27 July 2015

Department of Planning and Environment
23-33 Bridge Street
Sydney NSW 2000

**Letter of objection to Staged Concept Proposal SSD 6454– SCEGGS Redlands 272 Military Road, Cremorne (Proposal)
Unit 1/19 Waters Street Neutral Bay NSW (Property)**

Project REDLANDS SENIOR CAMPUS MASTERPLAN Drawing Title PROPOSED MASTERPLAN - BASEMENT AND LEVEL 1 PLANS Drawing No. AR-MP-2001	Revision A

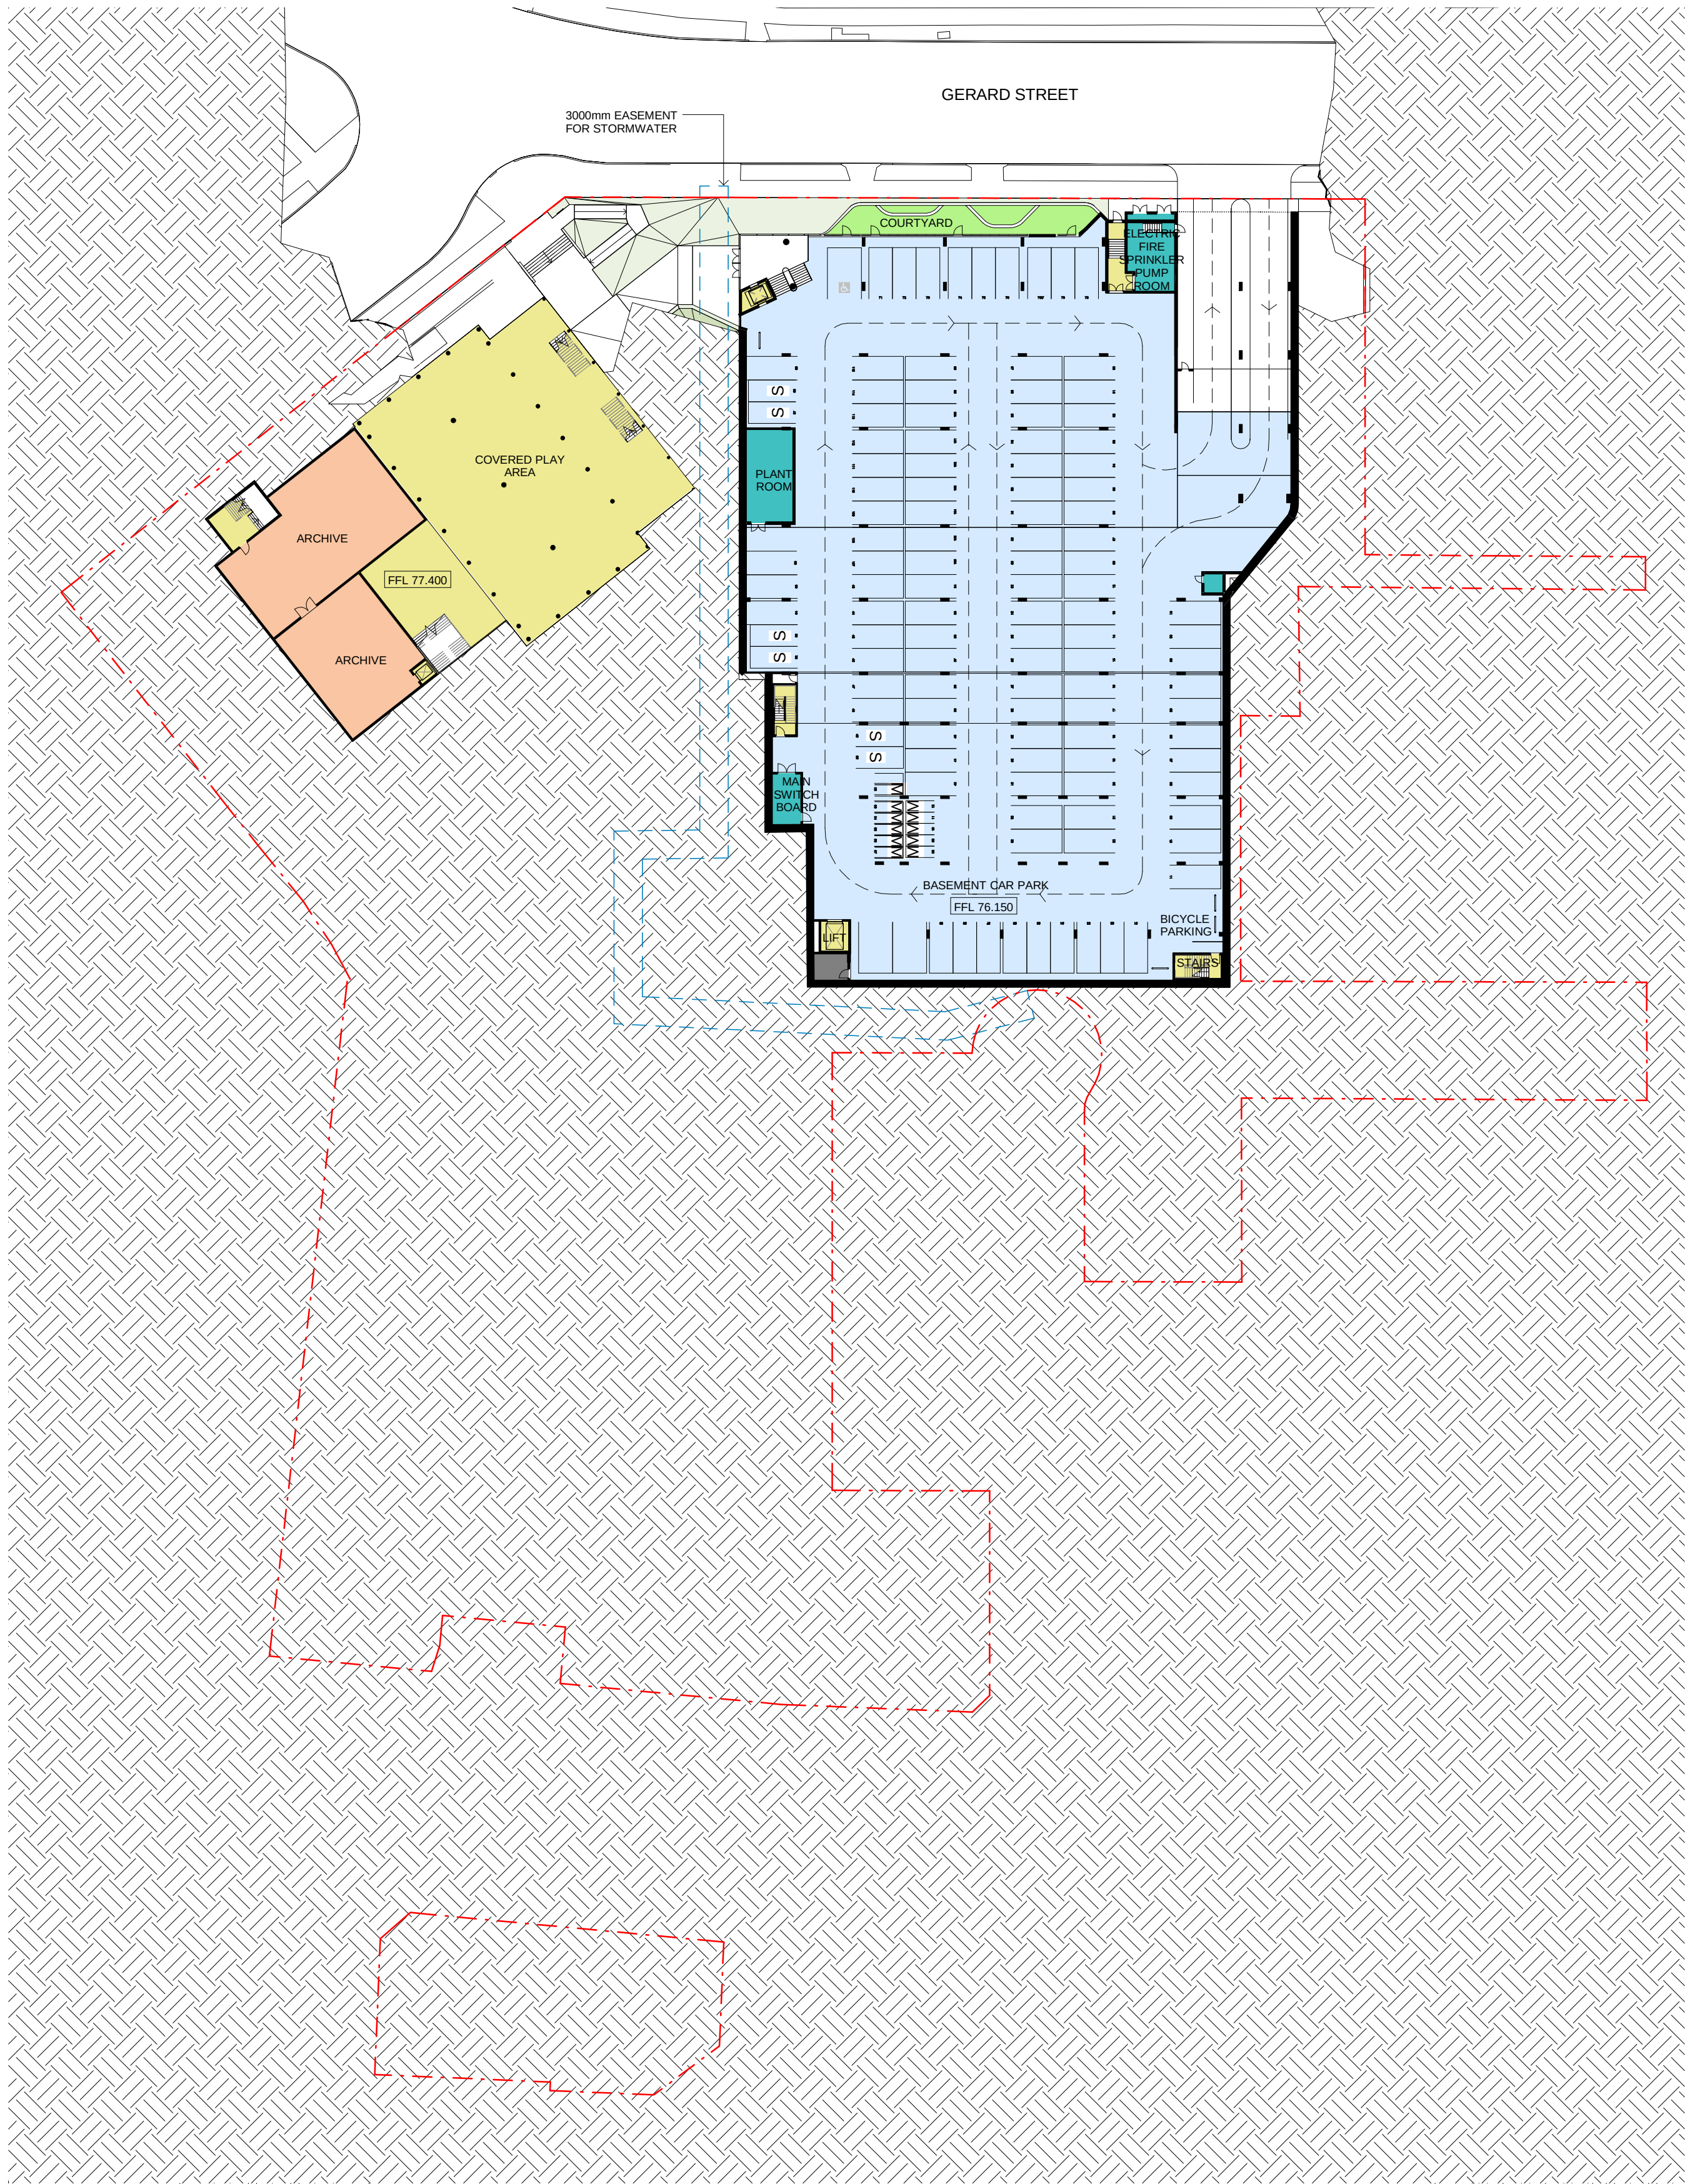
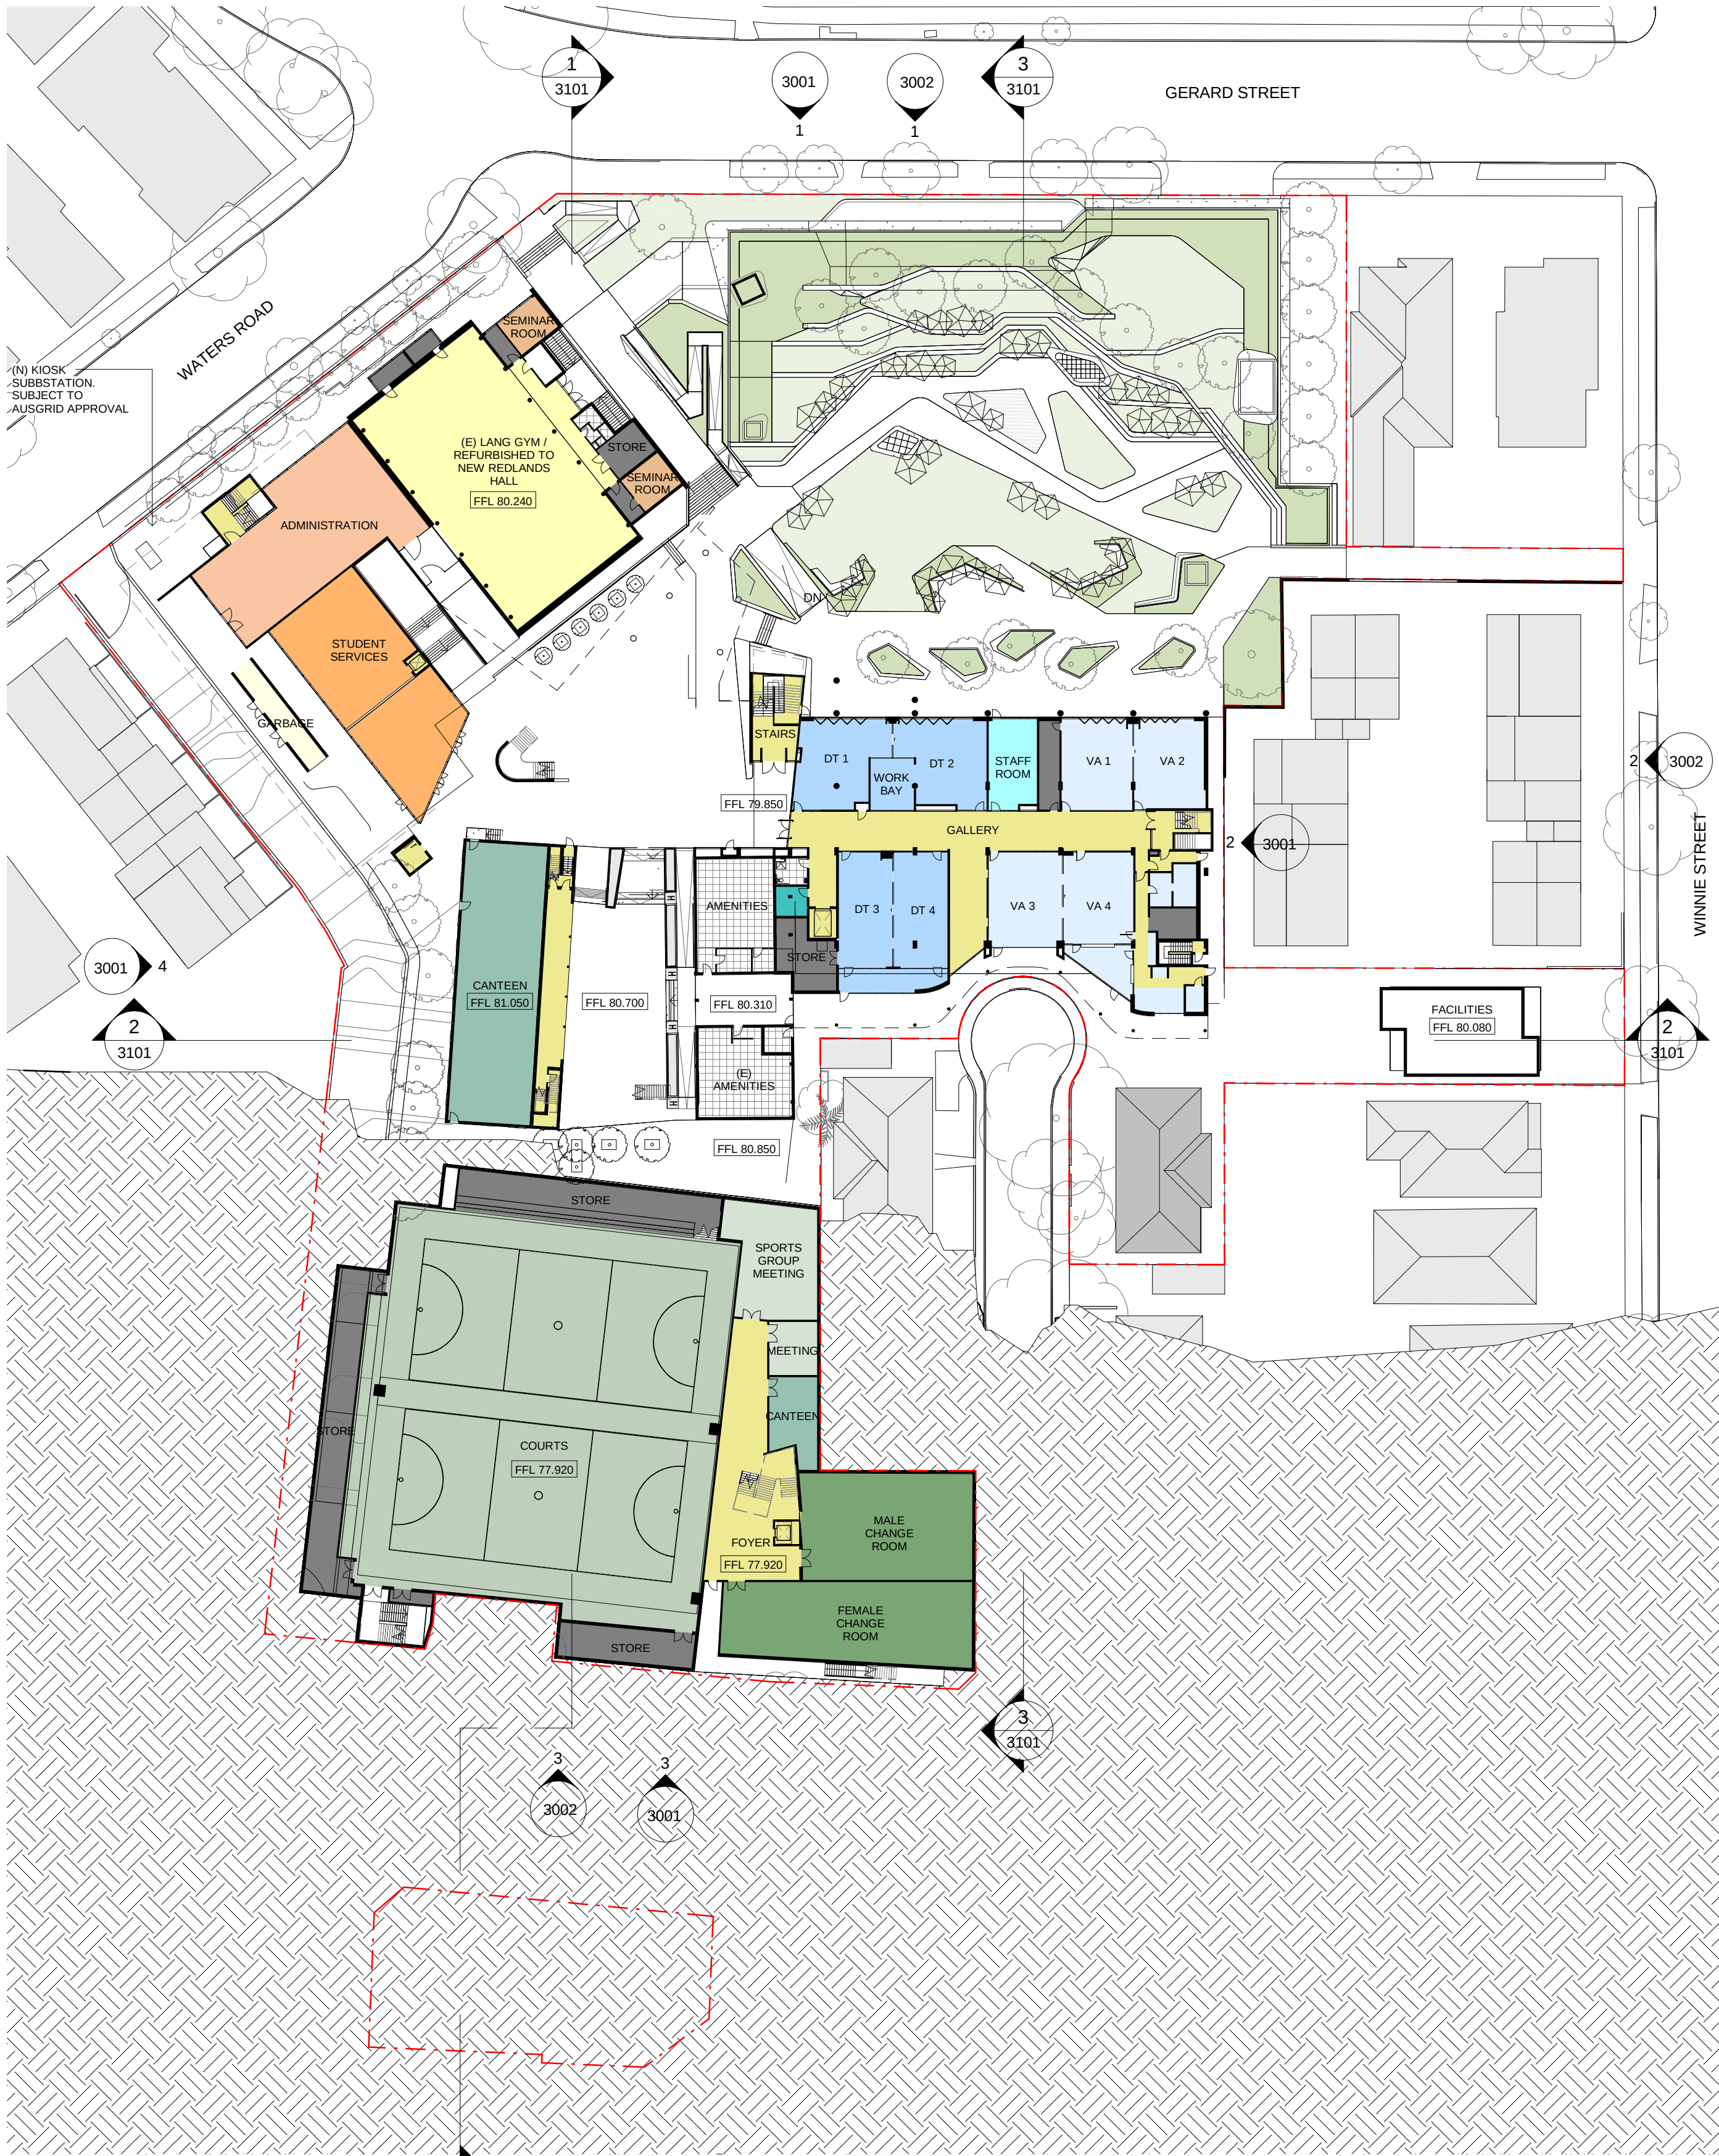
15. The diagram below extracted from the application plans shows a large garbage area within or adjacent to the Humphrey building and demonstrates that access to the garbage area for the Proposal is directly adjacent to our client's property (though notably the adjacent residences are not shown on the plan). This will result in garbage trucks using the access lane on a weekly or daily basis, which is both noisy and potentially smelly, and strongly objected to by our client.

16. The large garbage area is proposed to be located directly adjacent to the backyards of the residential properties, off the access handle.
17. Our client's only private open space, lounge room and bedroom all face onto the proposed access handle. This means that our client and other residents will be subjected to the noise and smell of regular garbage truck movements.
18. The location of the access handle and garbage room are completely inappropriate, and push the unacceptable impacts of noise, traffic and garbage trucks onto the neighbouring residences, rather than containing these impacts internally within the development.
